An
Bord
Pleanála

Inspector's Report ABP-311482-21

Whether internal and external works to an apartment building constitutes development and if so whether that development can be considered exempted development.

Apartment Q, Coliemore Apartments,
Dalkey, Co. Dublin.

WORKS ITEM 6

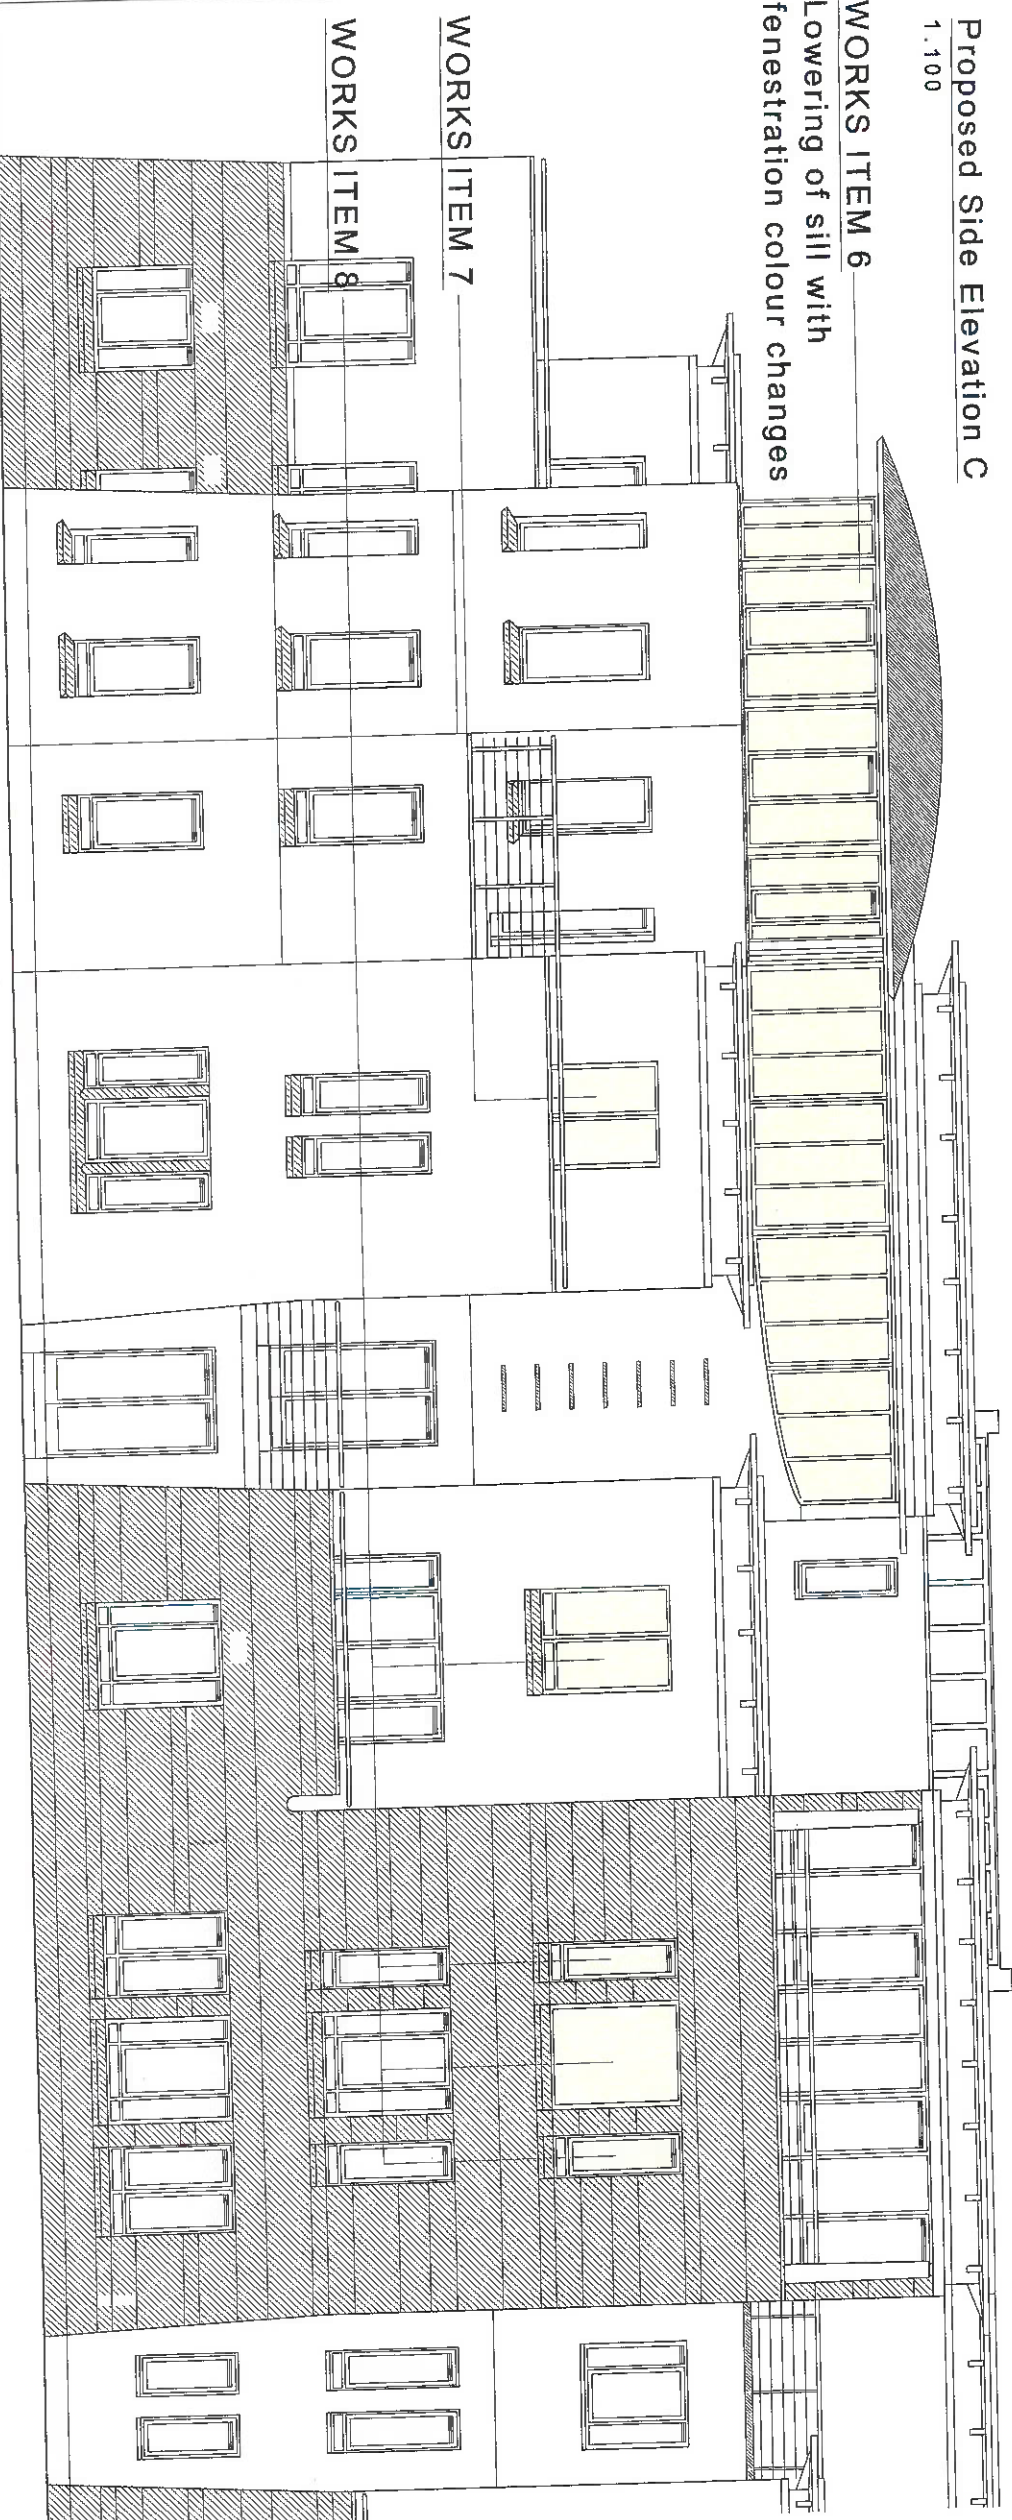
8.7. Item 6 – Lowering of sill with fenestration colour change

8.7.3. I have concluded (as per Item 5 above) that the cumulative impact of Item 3 and the replacement of adjoining windows would not materially affect the external appearance of the structure so as to render the appearance inconsistent with the character of the structure or of neighbouring structures. Item 6 involves a variation of Item 5, whereby the fenestration division within the rotunda would be retained and the revised fenestration pattern for the remainder of windows at 3rd floor level would be more consistent with the existing windows.

8.7.4. Accordingly, the extent of alterations in Item 6 would be less than those outlined in Item 5. And for the same reasons as those outlined regarding Item 5, I do not consider that these cumulative alterations would materially affect the external appearance of the structure so as to render the appearance inconsistent with the character of the structure or any neighbouring structures.

8.7.5. Accordingly, I am satisfied that Item 6 would be exempted development in accordance with the provisions of s. 4(1)(h) of the Act.
